From: Euan Clark - Folkes Architects [REDACTED]
Sent: 10 December 2019 14:52
To: Anita Gardner <Anita.Gardner@arun.gov.uk>
Subject: RE: 10053: Toddington Lane Littlehampton, Arun District, BN17 7PN APP/C3810/W/18/3197149 (LU/162/17/PL) Condition 14

Having double checked through the drawings, it looks like GTA Civils have prepared a new drawing (ref: 304) which has been prepared to specifically address condition no.14. The other drawing confirms the extent of Highway owned land, and was sent to WSCC for their information.

I am contacting you in regards to the development at Toddington Lane (LU/162/17/PL) and condition 14. In your comments on 15th October 2019 you asked for A visibility splay of 2.0m * 66m in both directions at the western end of the proposed footway. This was to ensure any pedestrians crossing in this location have sufficient visibility to see any oncoming cars. The 66m visibility splay is achievable looking west but not looking east.

Visibility Splay Site Plan - 1:200 @ A1

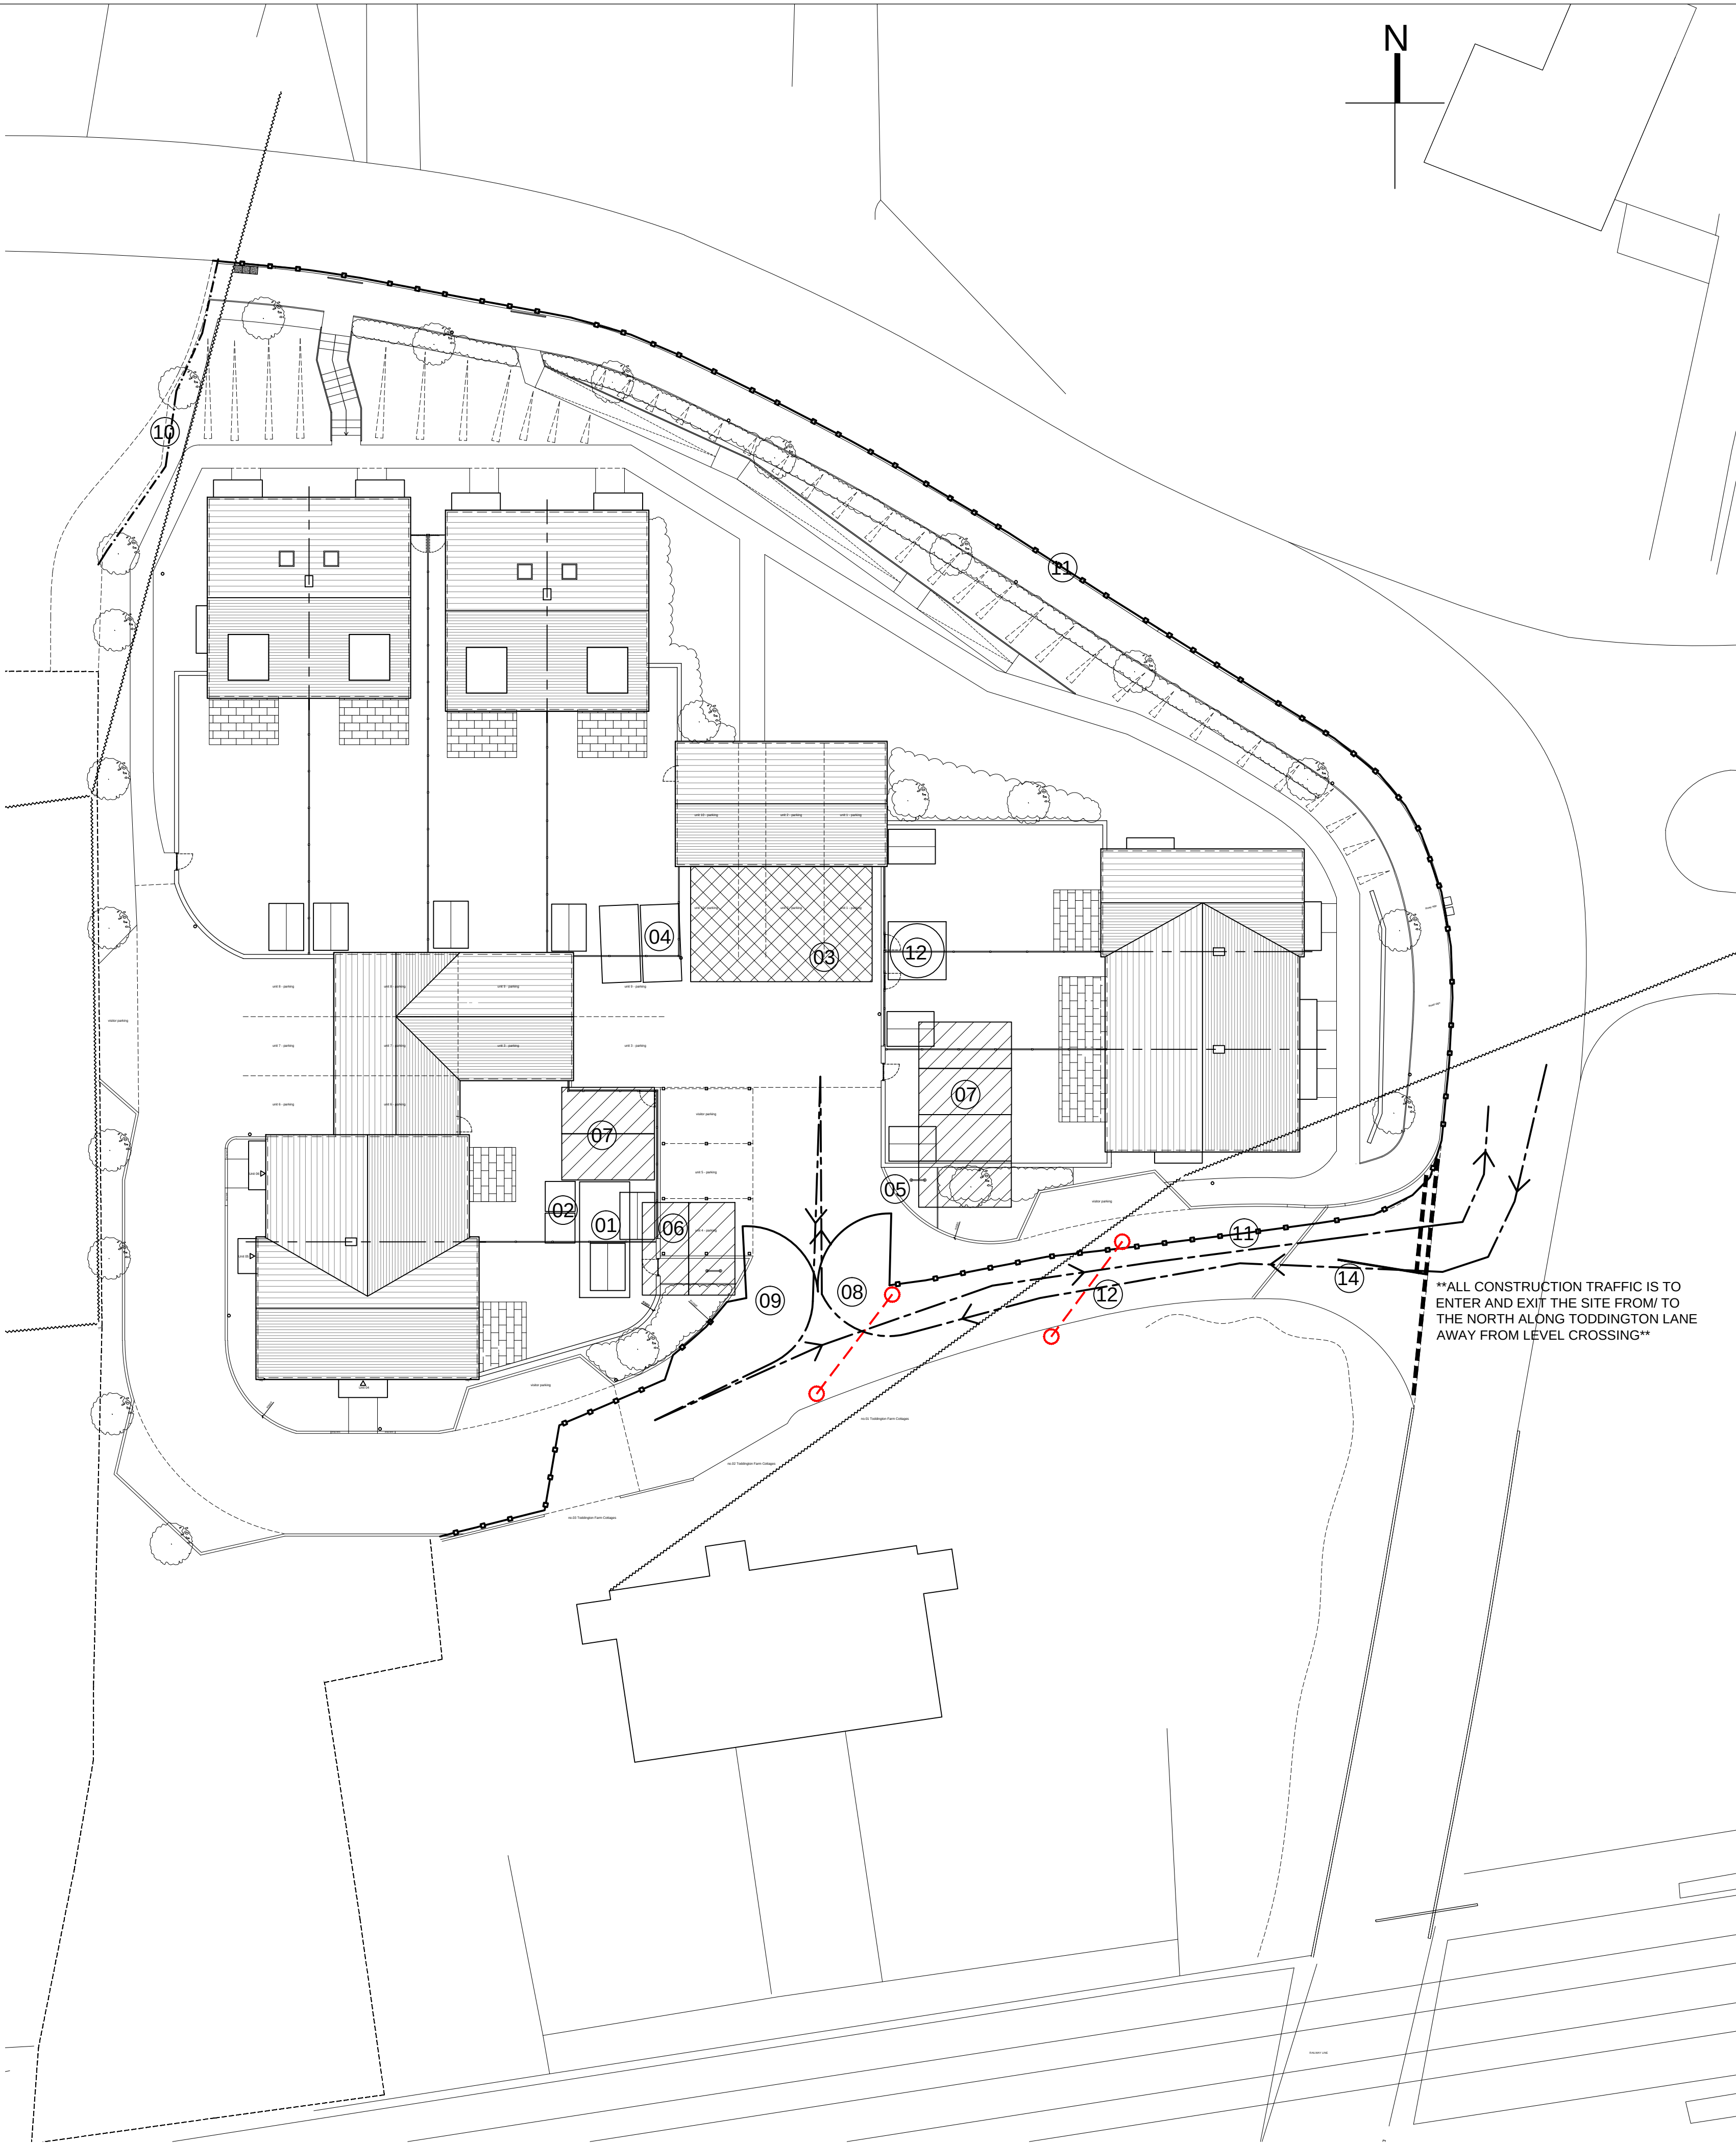
Can I take it then that drawing 2.32 Rev A is the plan for vehicular visibility splays?

Further to receipt of these plans please can you confirm which drawing numbers are superseded and which plans relate to which condition.

Yes, that's correct – use our drawing 2.32A for the vehicular splays.

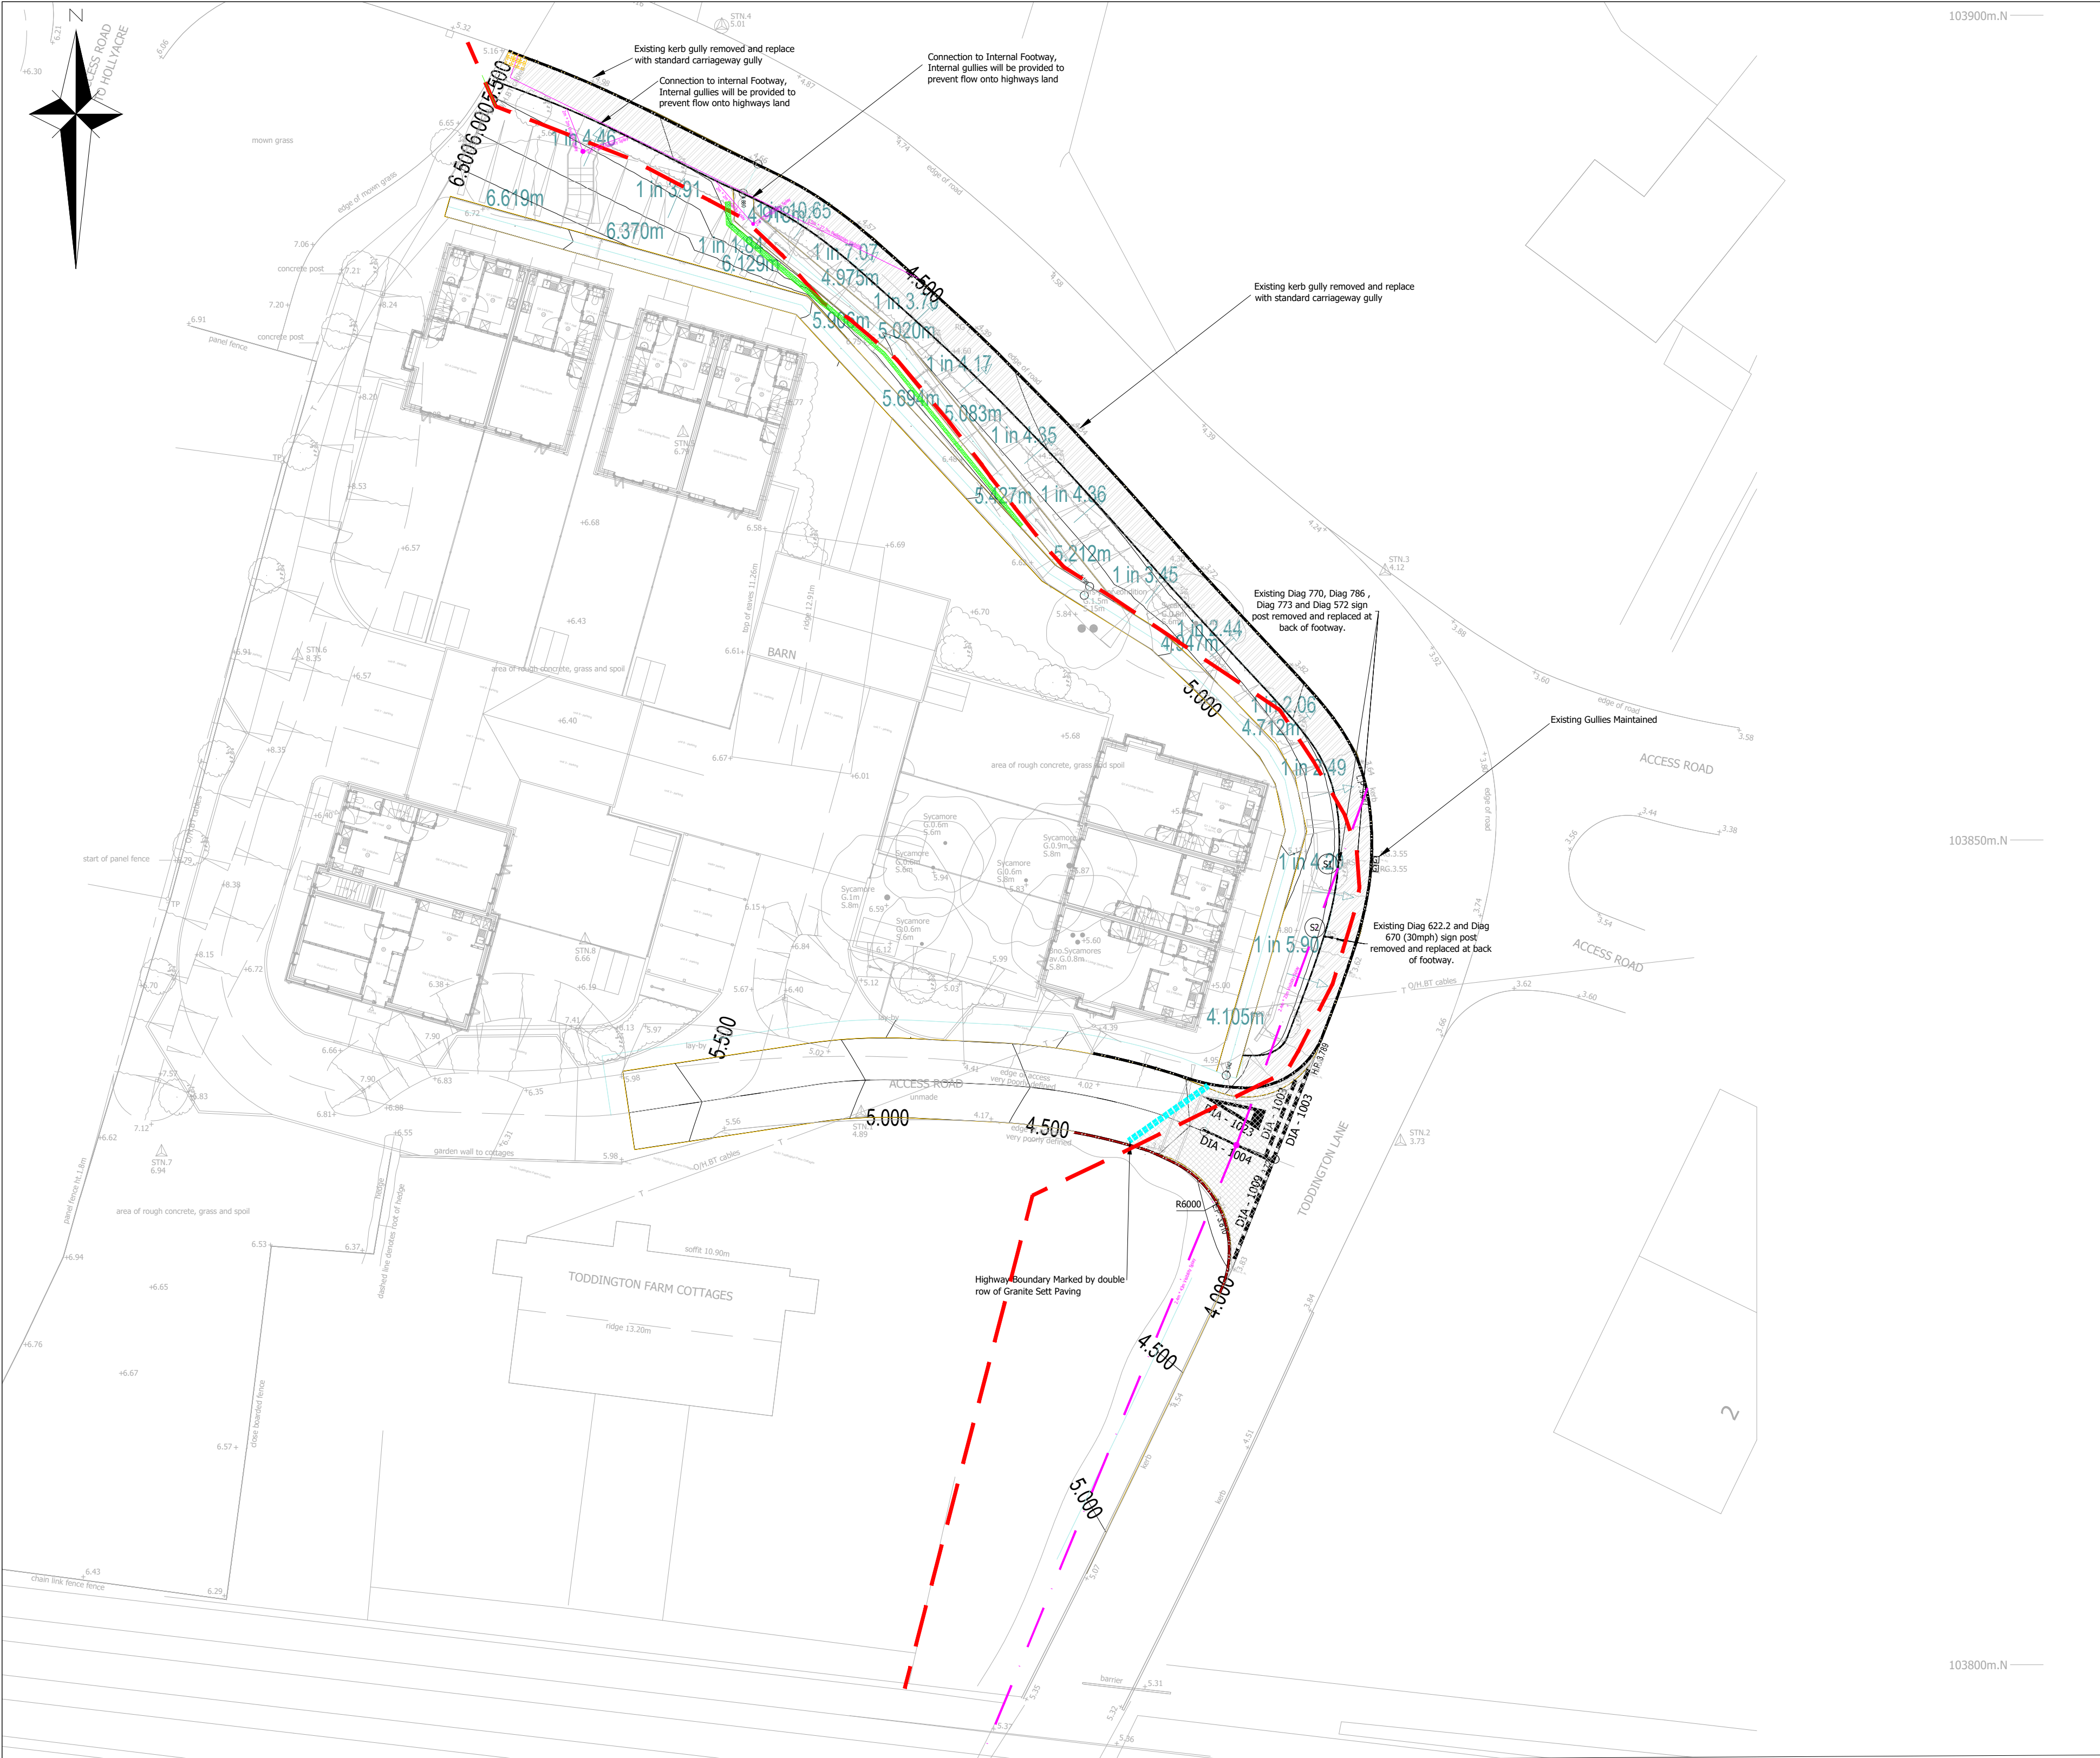
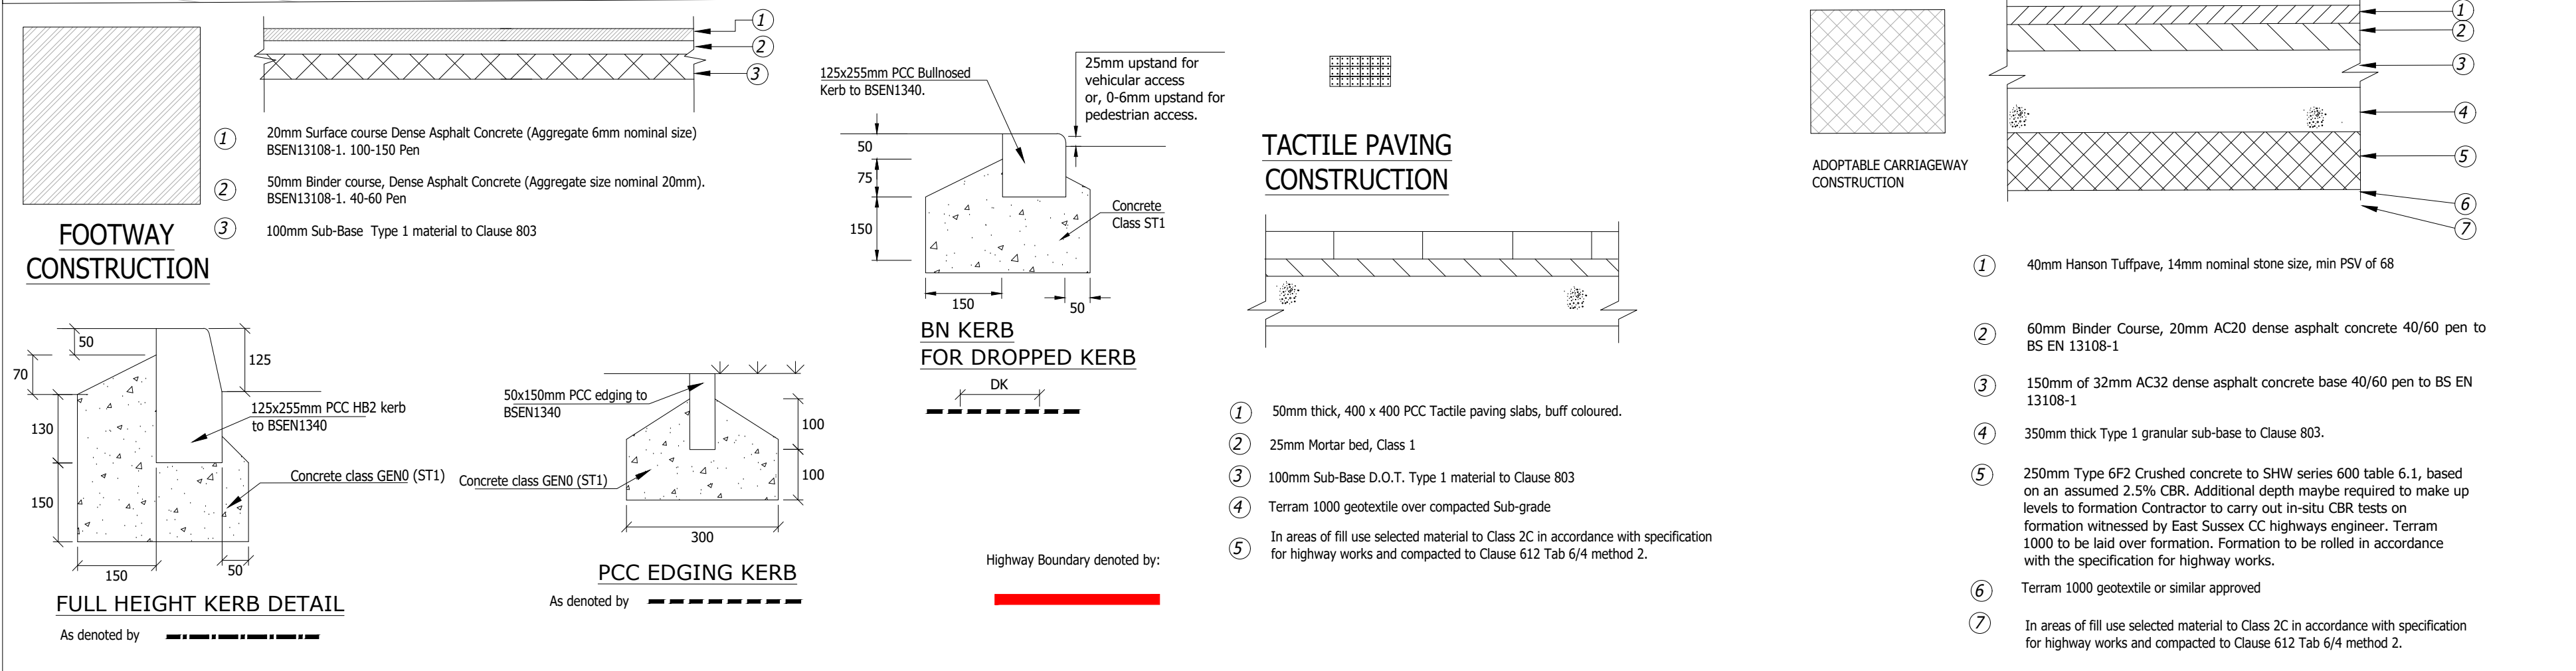
In principle I think we could accept the 1 metre. However just one point I would like to confirm, the 66 metre splay to the west can you confirm in a bit more detail it is all contained within highway land as it present it is not stated.

In order to ensure that the visibility splay looking west is entirely within highways land we can only guarantee a 59m visibility splay. In regards to this I would refer to my email to Tim from 19th November:

As such I would contend the 59m visibility splay entirely within the highway boundary should be acceptable.

I note that section 4 of WSCC design guide states that lightly trafficked residential roads have 85%ile speeds below 37mph, can have MfS1 standards applied. As this is the case for Toddington Lane, the 66m visibility splay is likely in excess of the stopping sight distance for westbound vehicles will need to see pedestrians. Using MfS1 standards and the recorded 28mph 85%ile speed there is a stopping sight distance requirement of 39m.

I also note that the visibility splay asked for is from 2.0m, the proposed footway is 2m in width and it is unlikely a pedestrian would be stood on the back edge of the footway, would a visibility splay from 1.0m be acceptable as this is likely to be more reflective of a pedestrians position on the footway.

With the above in mind I would suggest a 1.0m * 39m visibility splay should be acceptable and allow for the crossing point to function safely. Please see update site layout with the visibility splays, I have shown 66m looking westwards as this is achievable and 39m is achievable looking east. Please note I have shown the 39m visibility splay to 600mm off of the kerb to represent the likely position of a car.
